Location: 114 ANDERSON ST

has permission to Renovate/place of worship, enlarge prayer room, new bathrooms & HC ramp
provided that the person or persons, firm or corporation accepting this permit shall comply with all of the provisions of
the Statutes of Maine and of the Ordinances of the City of Portland regulating the construction, maintenance and use of
the buildings and structures, and of the application on file in the department.

Jeanie Bourke - Re: Muslim Community Center

1 FLOOR PLAN
SCALE: 1/8" = 1'-0"
2' 4' 8' 16'

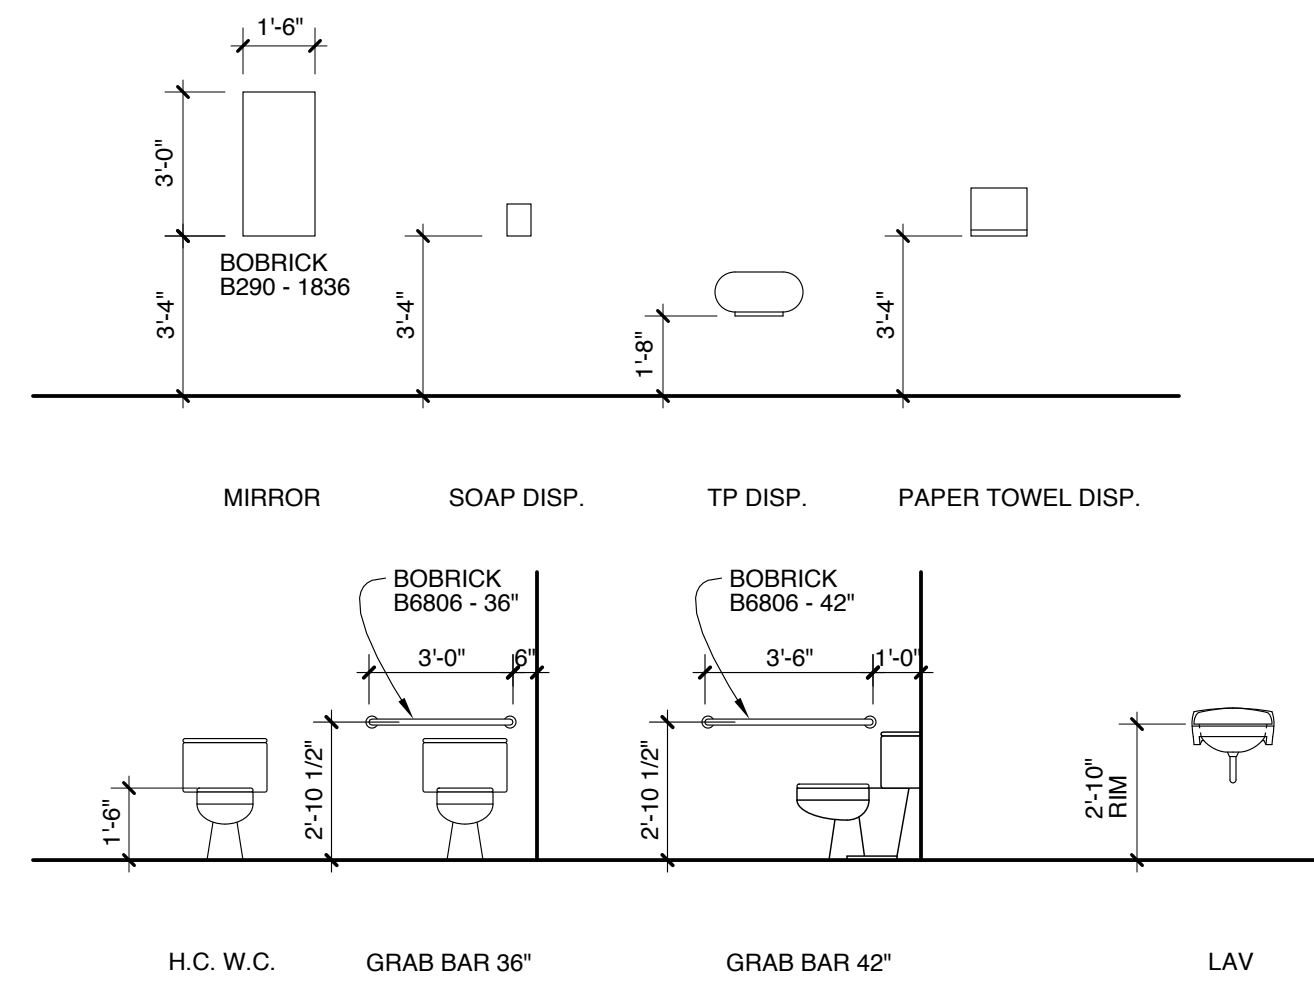
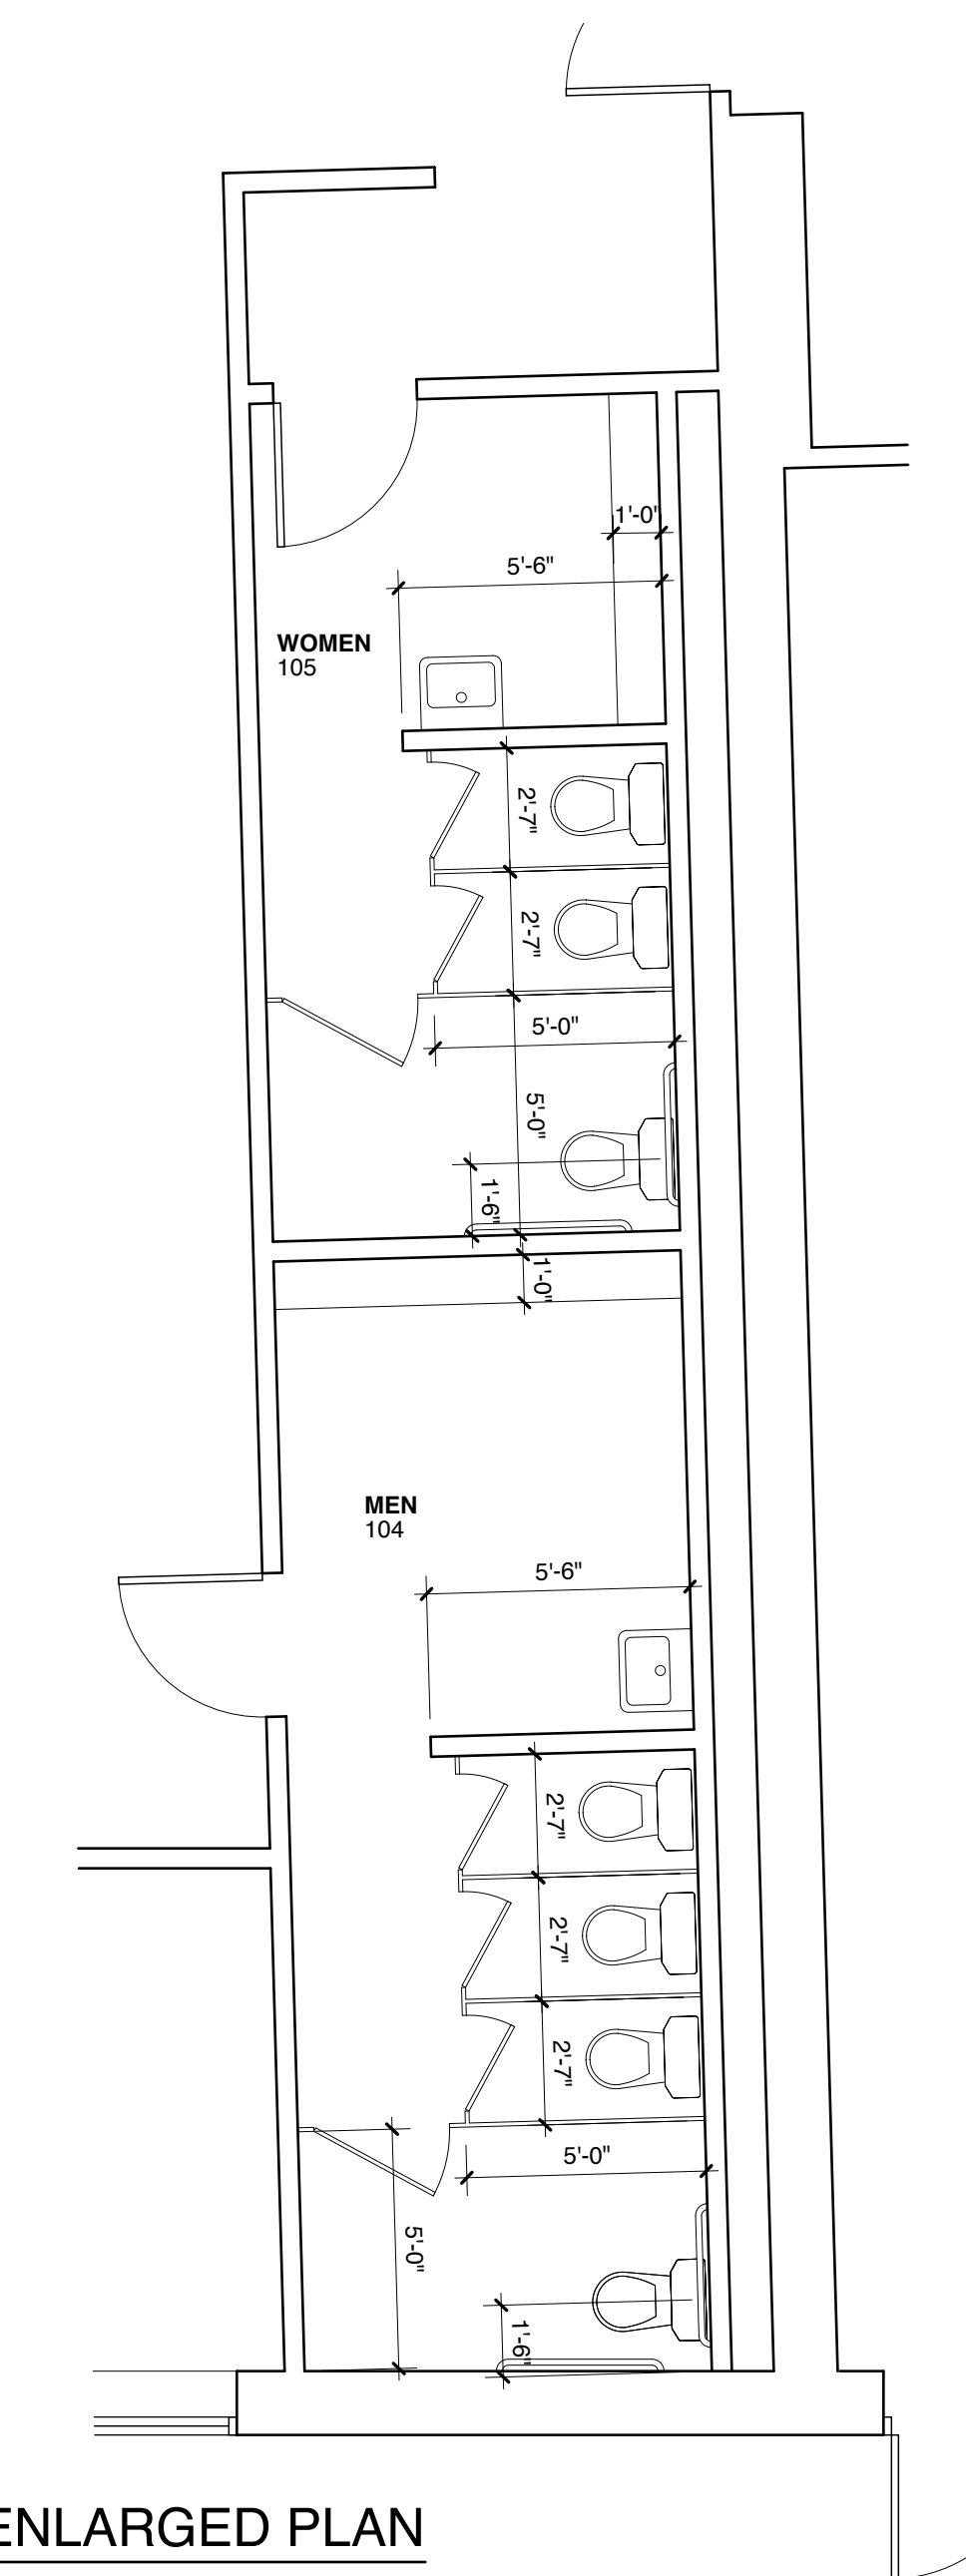
- update specification on P2 for a 2 hour wall
- specify the rated doors
- remove the steps as this is not approved on this permit and replace with a note that future amendment for new exterior door and entry steps

New exterior exit door and stair from Prayer Room 112.
2-hour fire separation partition noted.
Drinking fountain added in Hall 106 adjacent to the cabinets.
Door swing reversed on door to Play Room 101.
Typical worshipper positions laid out in Prayer Room 112, shown on Sheet A2.
